Reference No:	2025/62/93105/W
Site Address:	3, Woodsome Drive, Fenay Bridge, Huddersfield, HD8 0JR
Description:	Demolition of existing garage and outbuilding, two storey side extension, single storey rear extension, front porch and roof canopy
Recommending Officer:	Joshua Merriman

DECISION – Conditional Full Permission

Officer Report – 2025/93105

title  
**Proposed Site Plan OPTION 3 (DRAFT)**

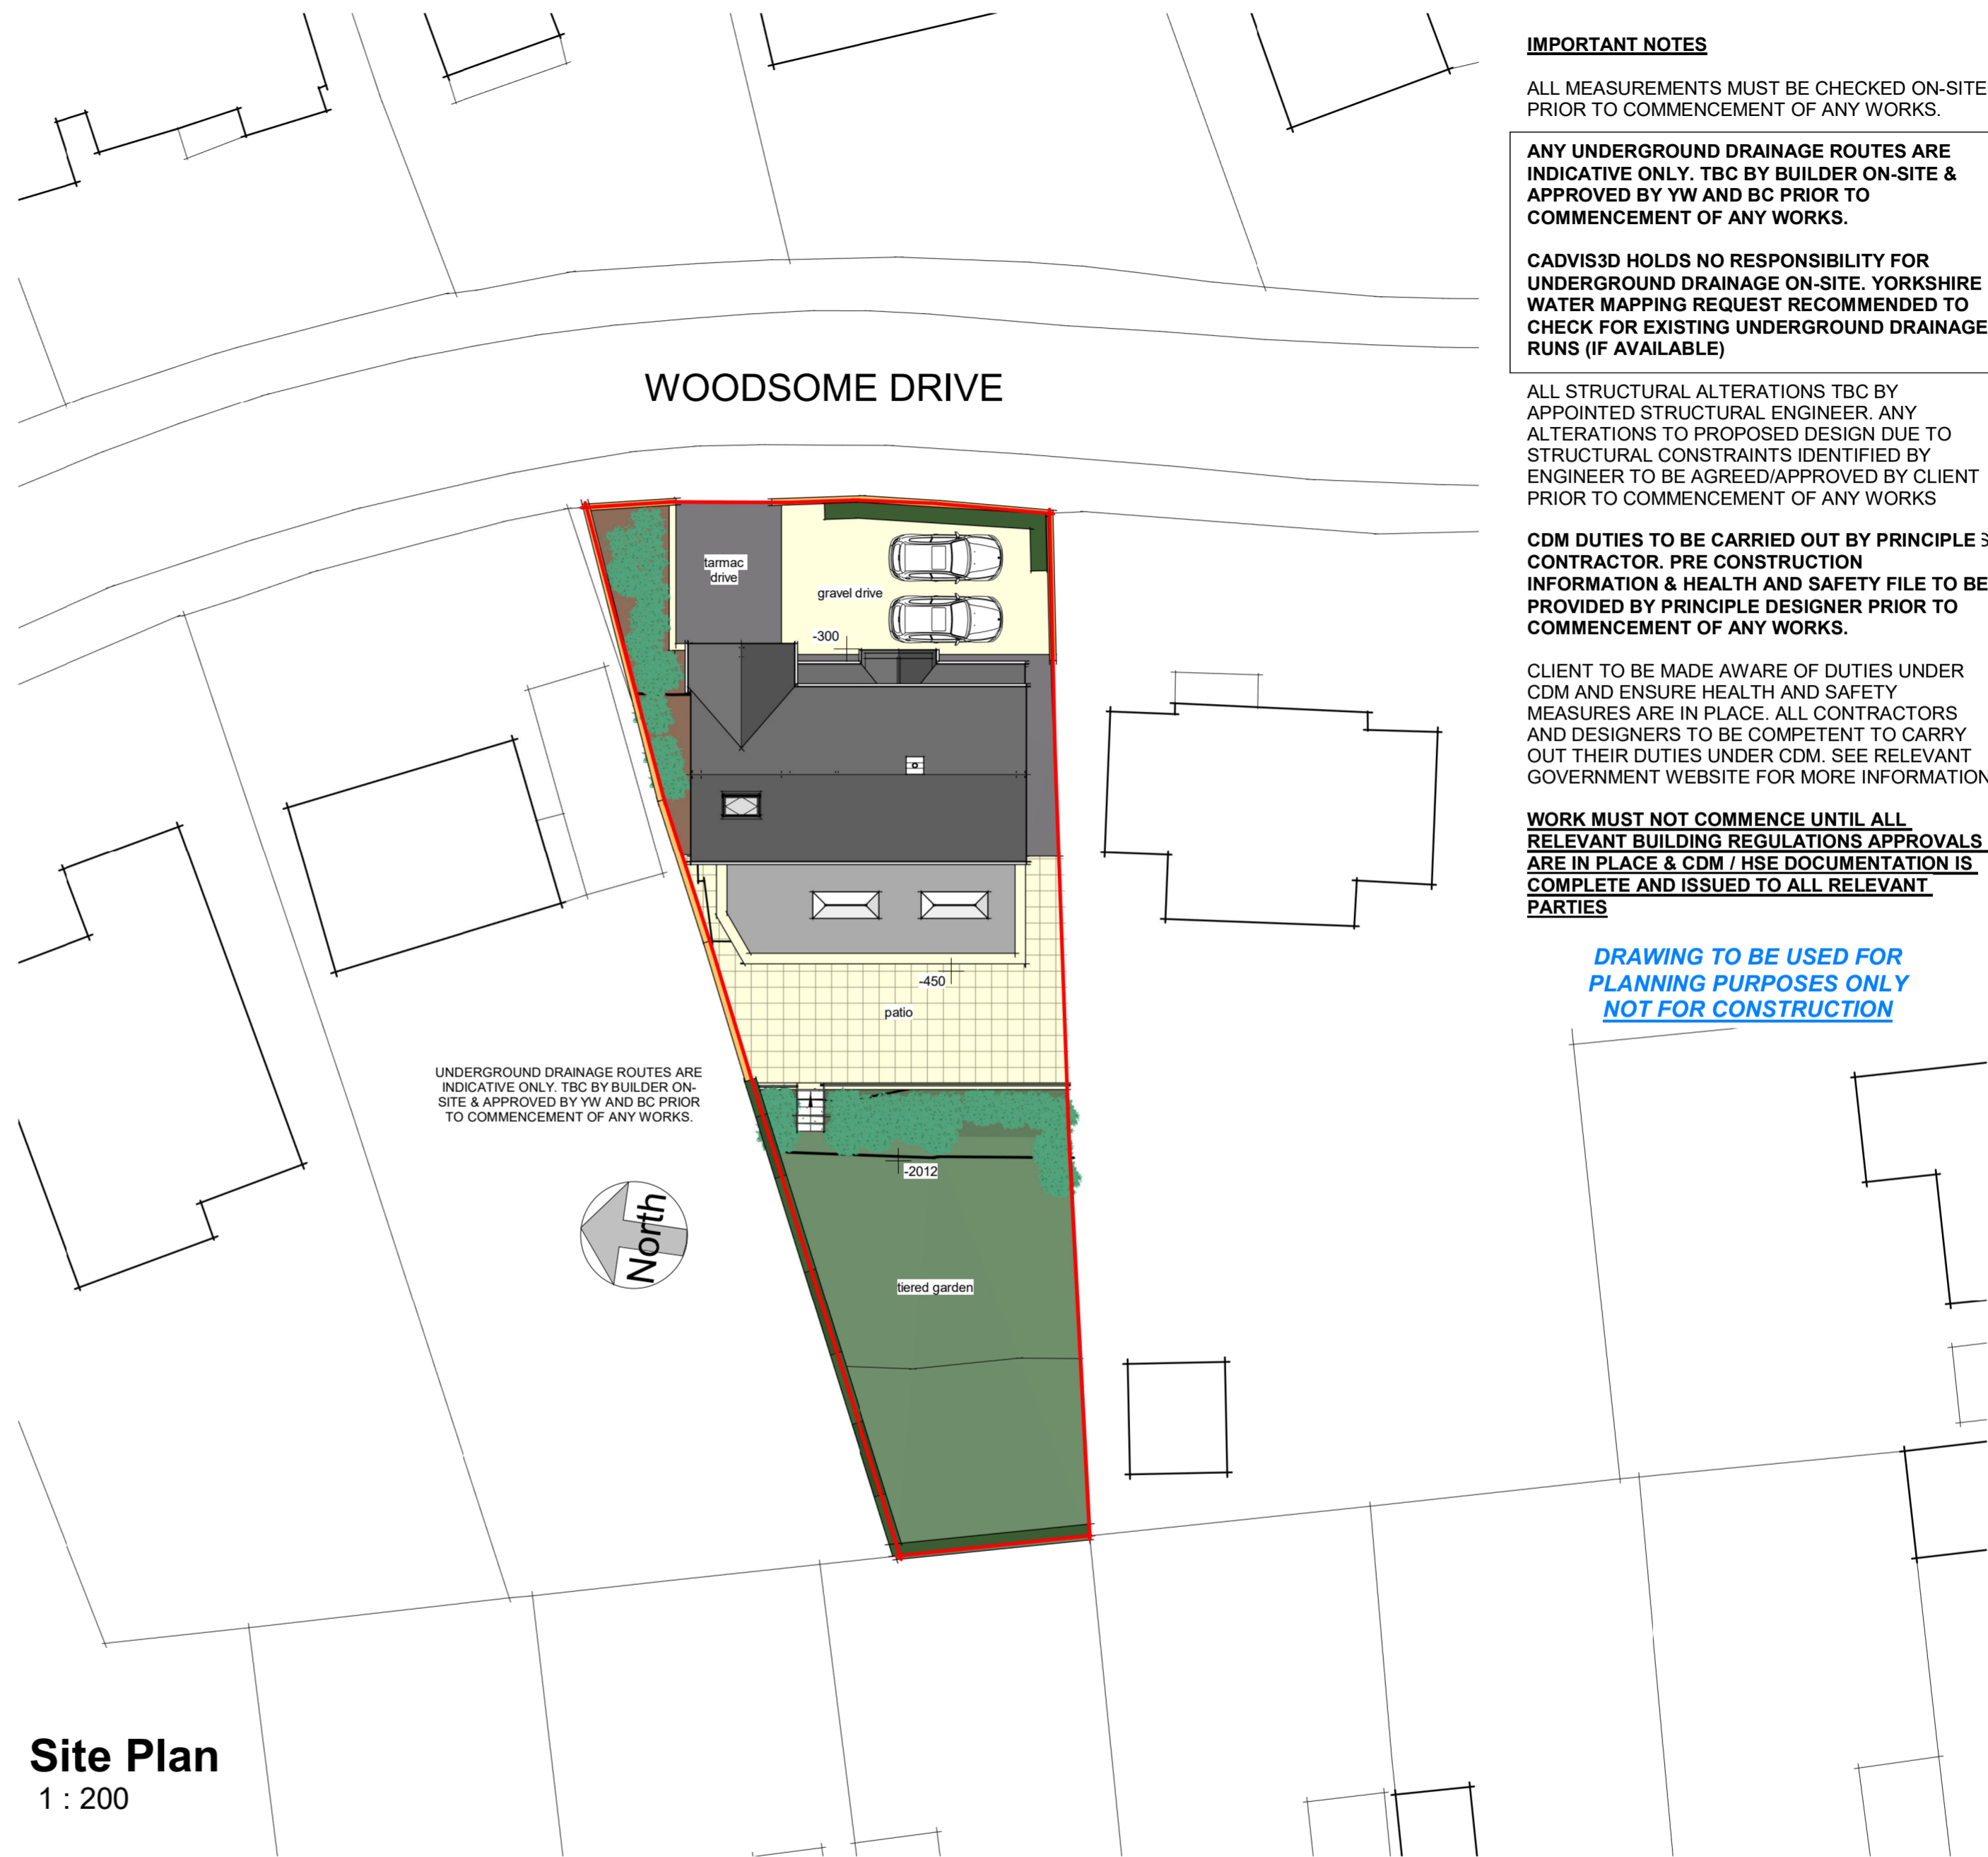
The number of bedrooms in the property will increase from three to four as a result of the development, however, the hard-standing parking area on site will not be reduced significantly in scale, and the proposed site plan shows adequate space for three off-street parking spaces, therefore, the current parking provision is acceptable to remain. Furthermore, the proposal will have no significant impact on highway safety as the dwelling is set well back from the closest highway.

title  
 Elevations - As Proposed

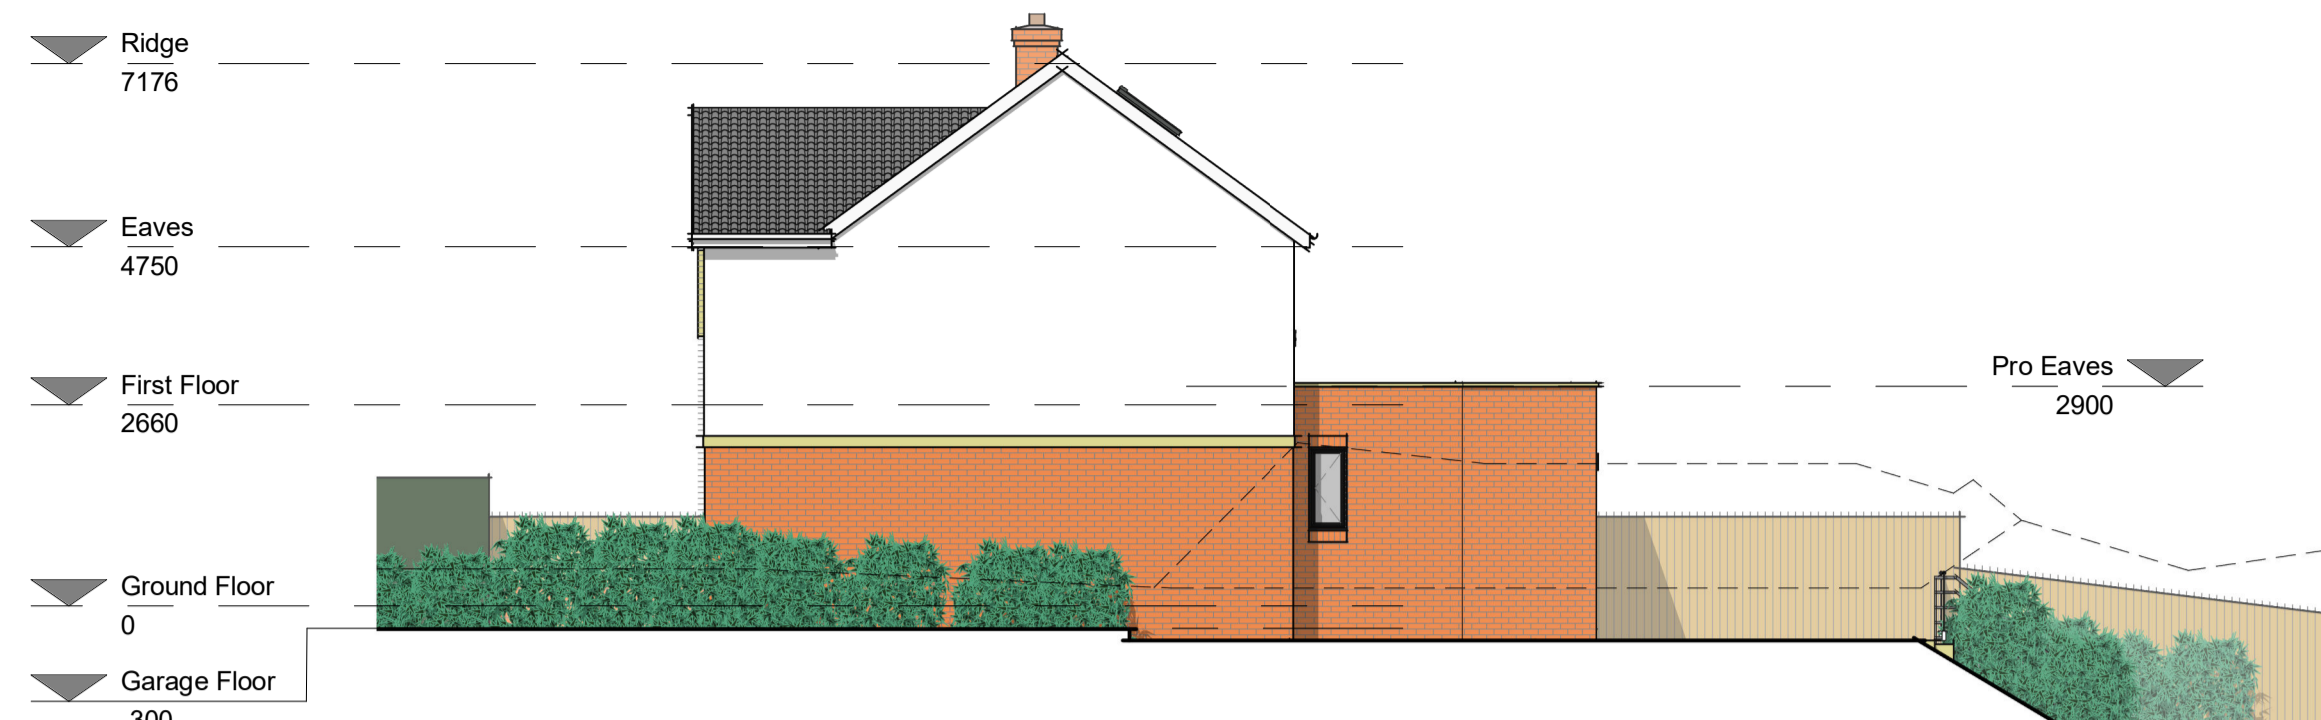
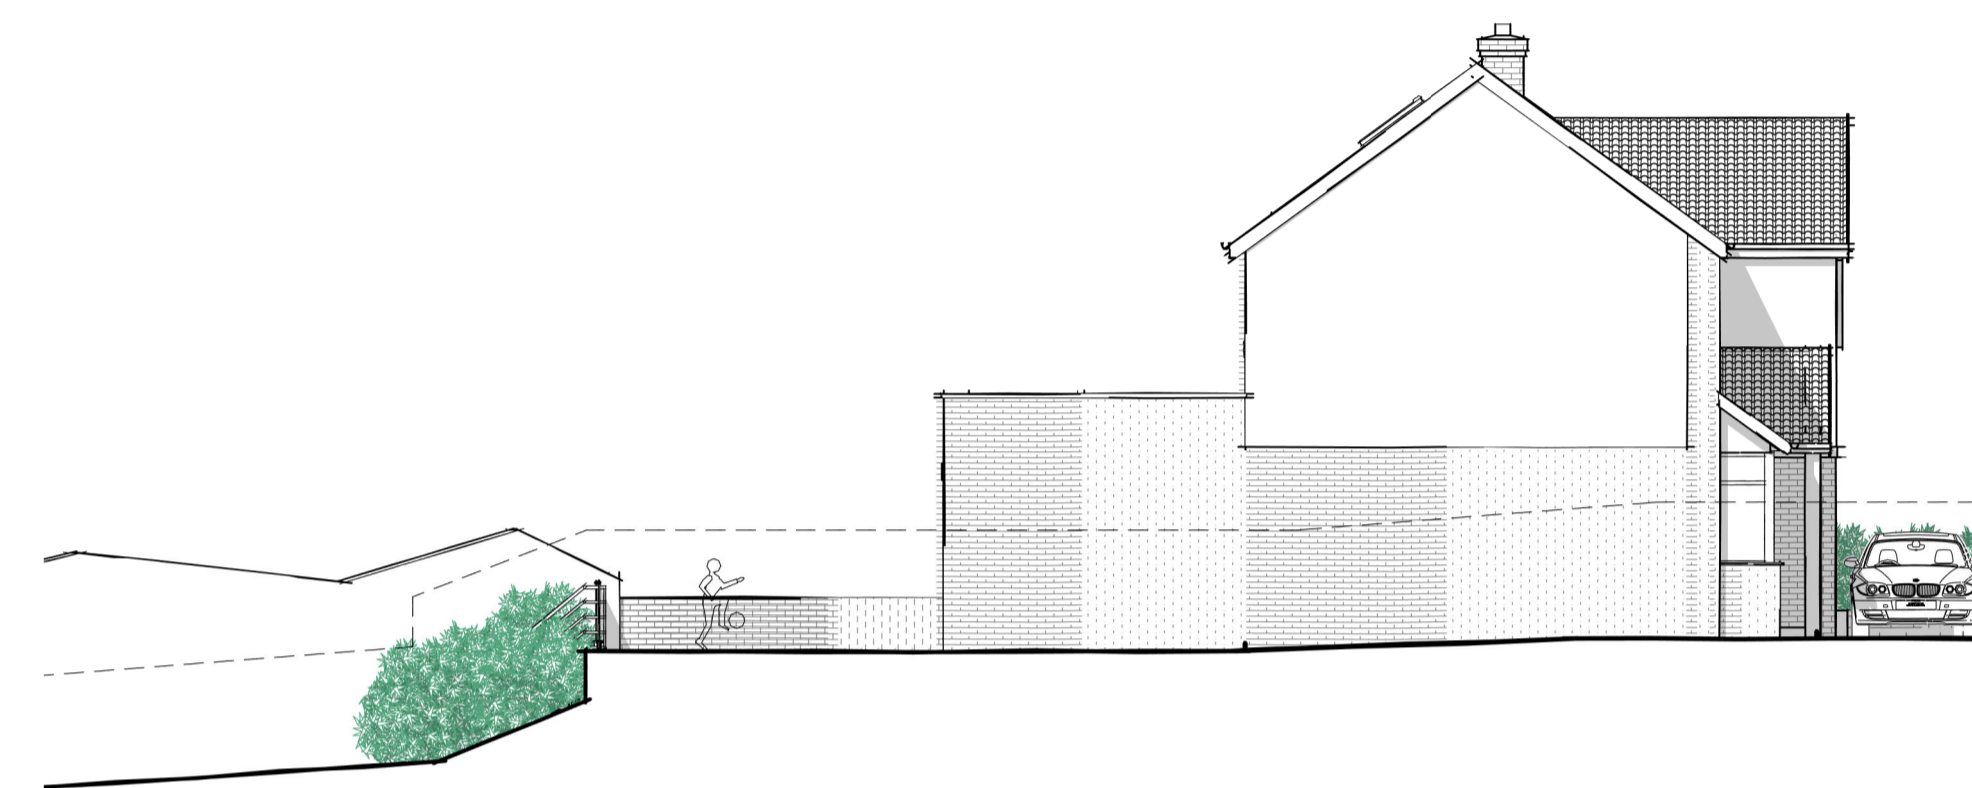
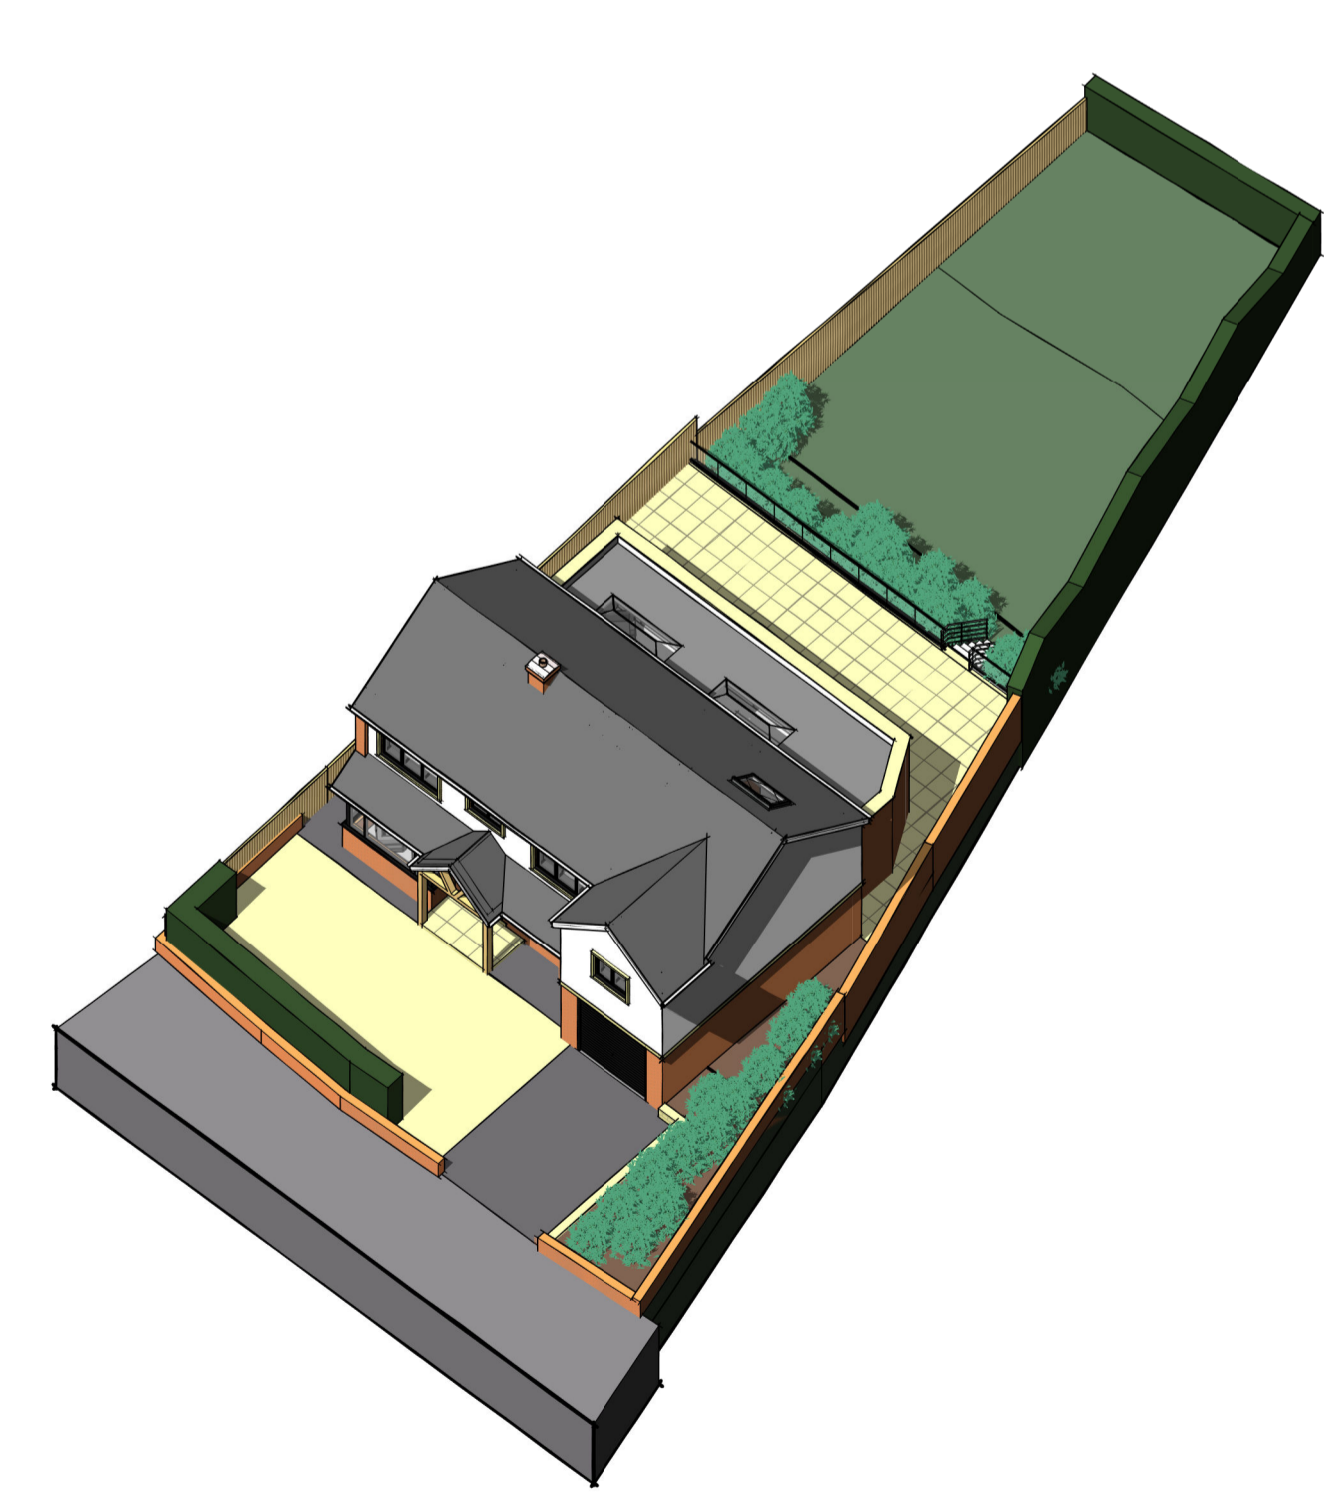
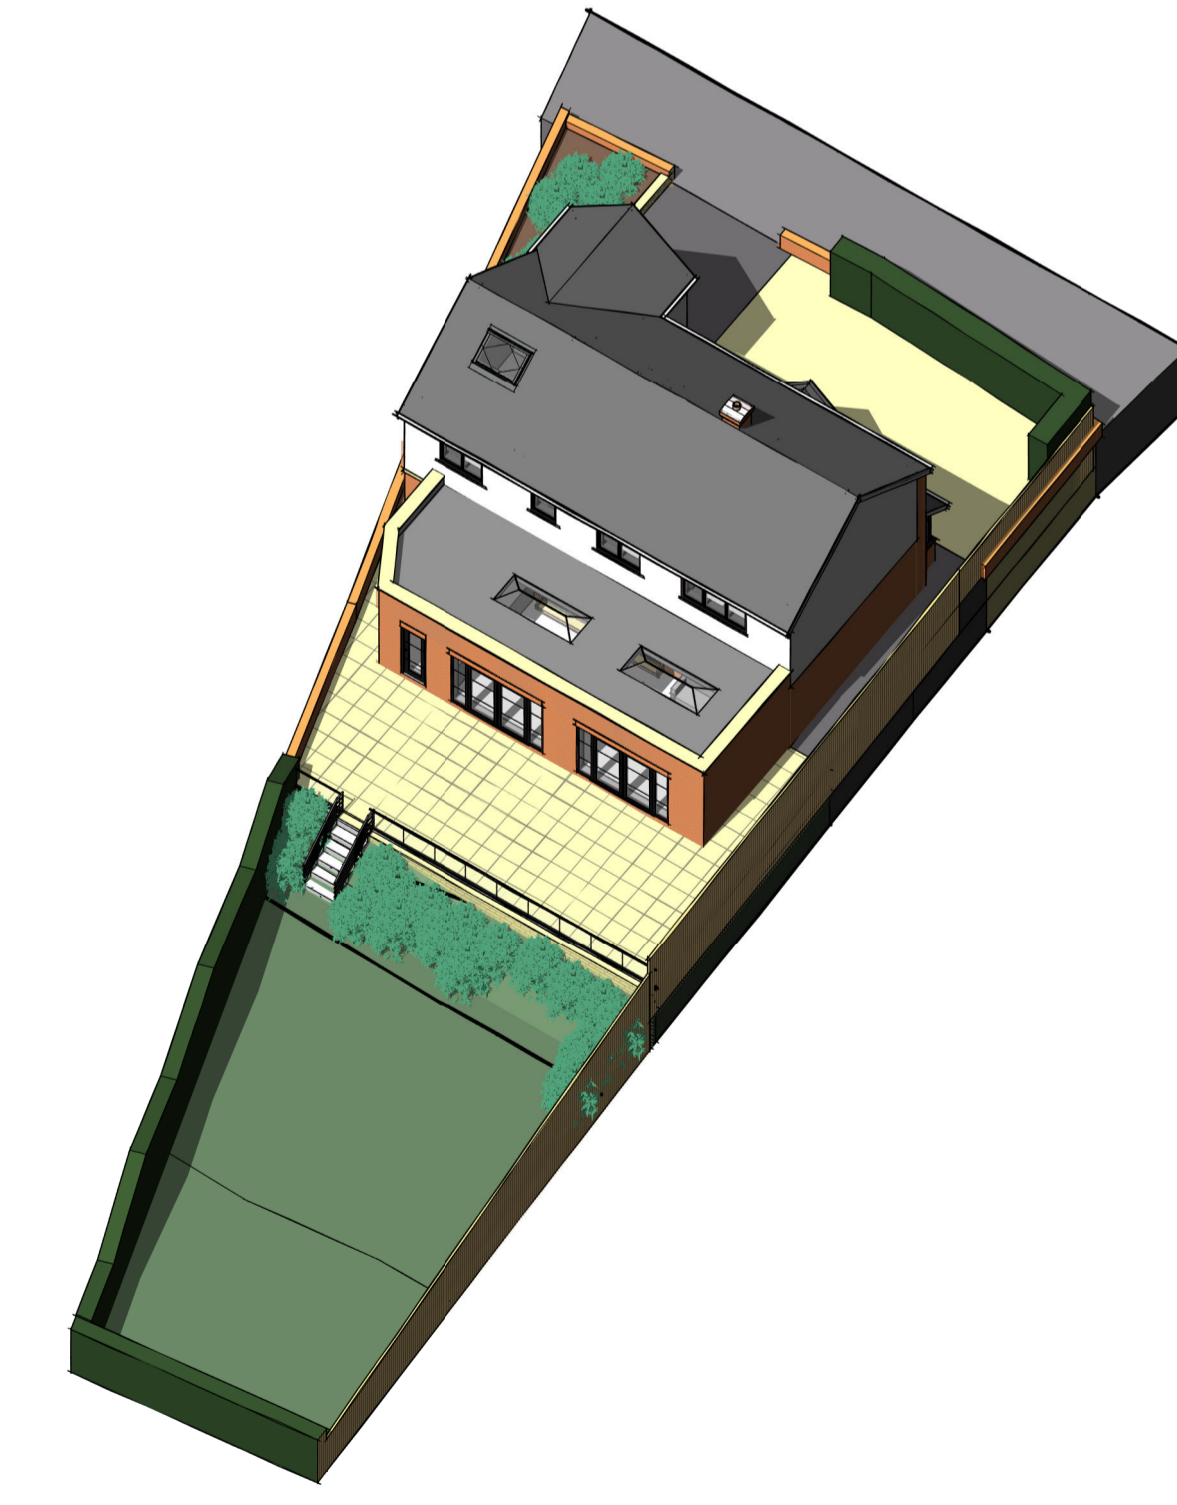
The proposed two storey side extension will project 3.72m from the side elevation of the existing building, with a maximum height of 7.77m, eaves height of 5.07m, and a depth of 7.82m.

The single storey rear extension will project 4.02m from the rear elevation of the existing house, with a maximum height of 3.39m, eaves height of 3.3m, and a width of 11.53m.

Finally, the front porch will project 1.46m from the front elevation of the existing building, with a maximum height of 3.83m, eaves height of 2.43m, and a width of 2.8m.

The single storey rear extension is entirely set behind the existing building, not projecting beyond the sides, and will use materials to match those of the existing building. Moreover, the proposal is considered to be subservient to

the host dwelling, does not exceed a height of 4m, and although the eaves height is above 2.5m, and projection slightly over 4m, it is considered that these have no significant impact upon visual amenity as the extension is located to the rear and not largely visible from the front of the house and street scene.

As for the two-storey side extension, an adequate gap is considered to be retained to the side of the house, preventing a terracing effect with the neighbouring property. Although the extension is not set back 500mm from the front elevation of the house, and projects further forward, it is considered that the proposed gable end facilitating this is sympathetic to the street scene and set well back from pavement as to have no impact upon visual amenity.

Finally, the front porch and canopy are considered small and subservient to the existing building, set well back from the pavement, and designed in sympathetic materials.
